Date: 13 March 2020

Planning Act 2008 – Section 89 and The Infrastructure Planning (Examination Procedure) Rules 2010 – Rule 8(3) and 17

Application by Norfolk County Council for an order granting development consent for the Great Yarmouth third river crossing project.

**DRAWING STATUS**  
FOR DCO EXAMINATION

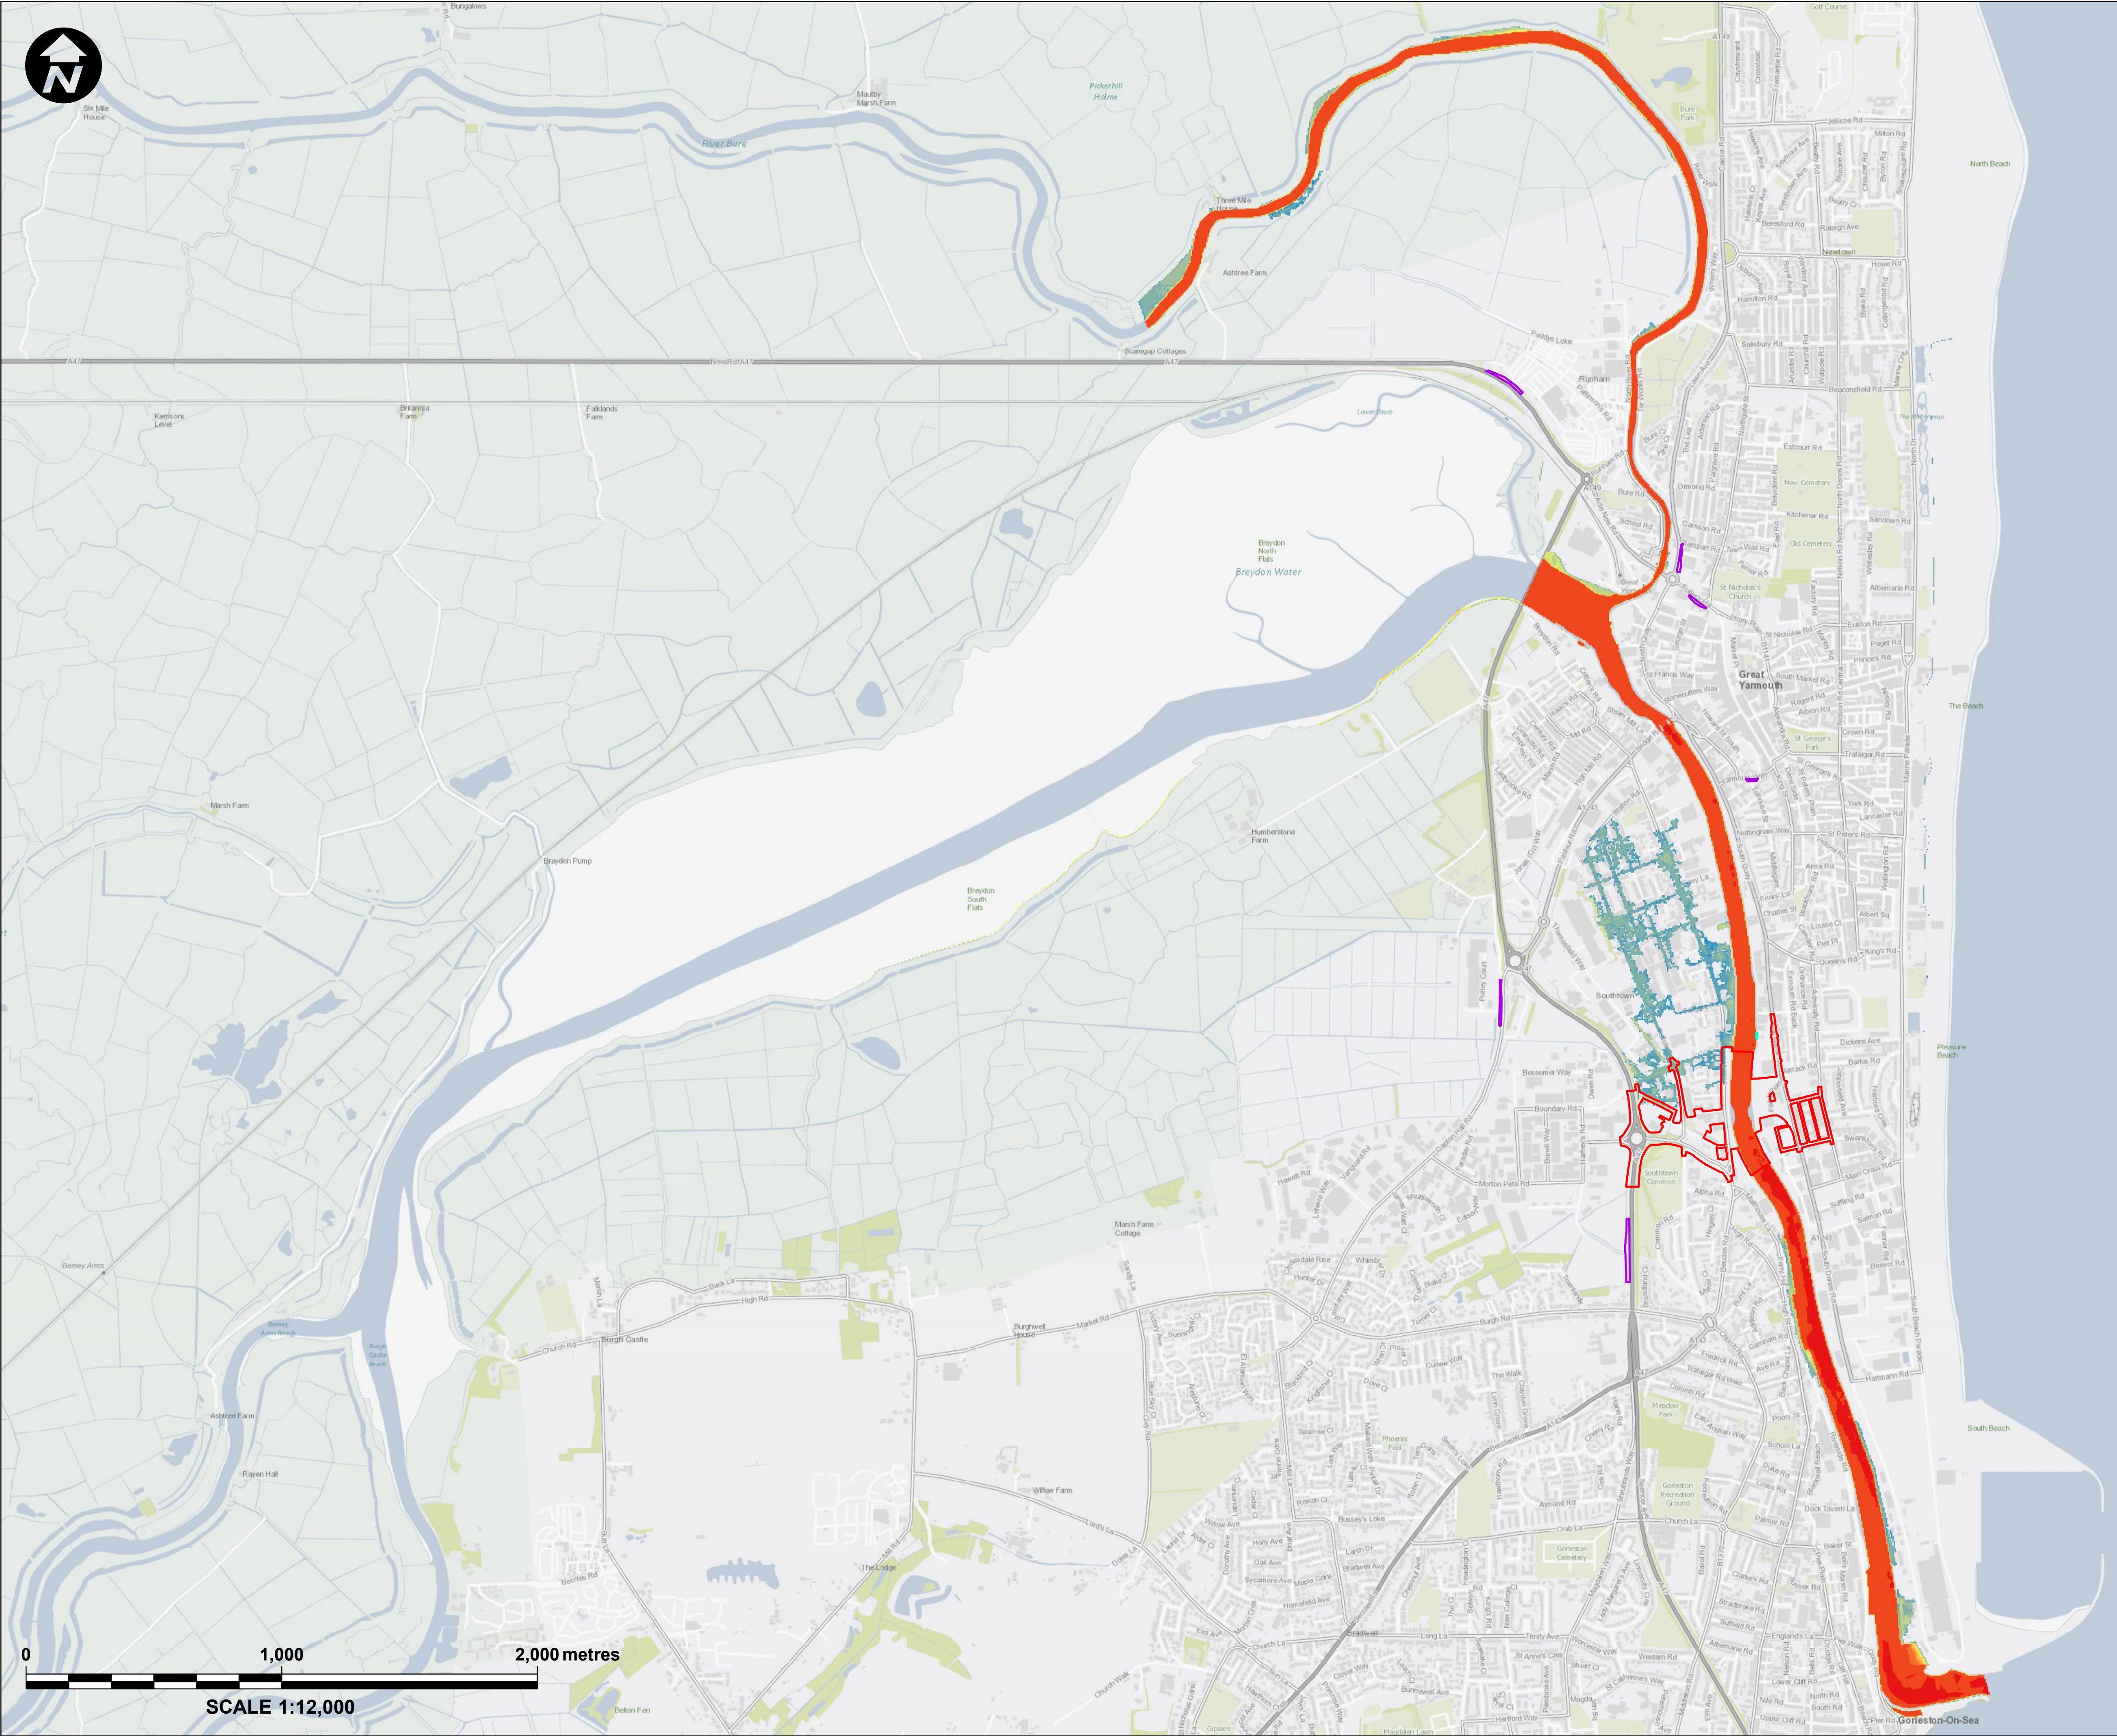
However, the figures used in the tidal residual (breach) risk analysis to show the difference in flood depth do not provide information that matches all the flood extents identified. Until this information is analysed and presented as part of the FRA the ExA is not informed regarding the change in hazard to third parties arising from the proposed development in the event of breach.
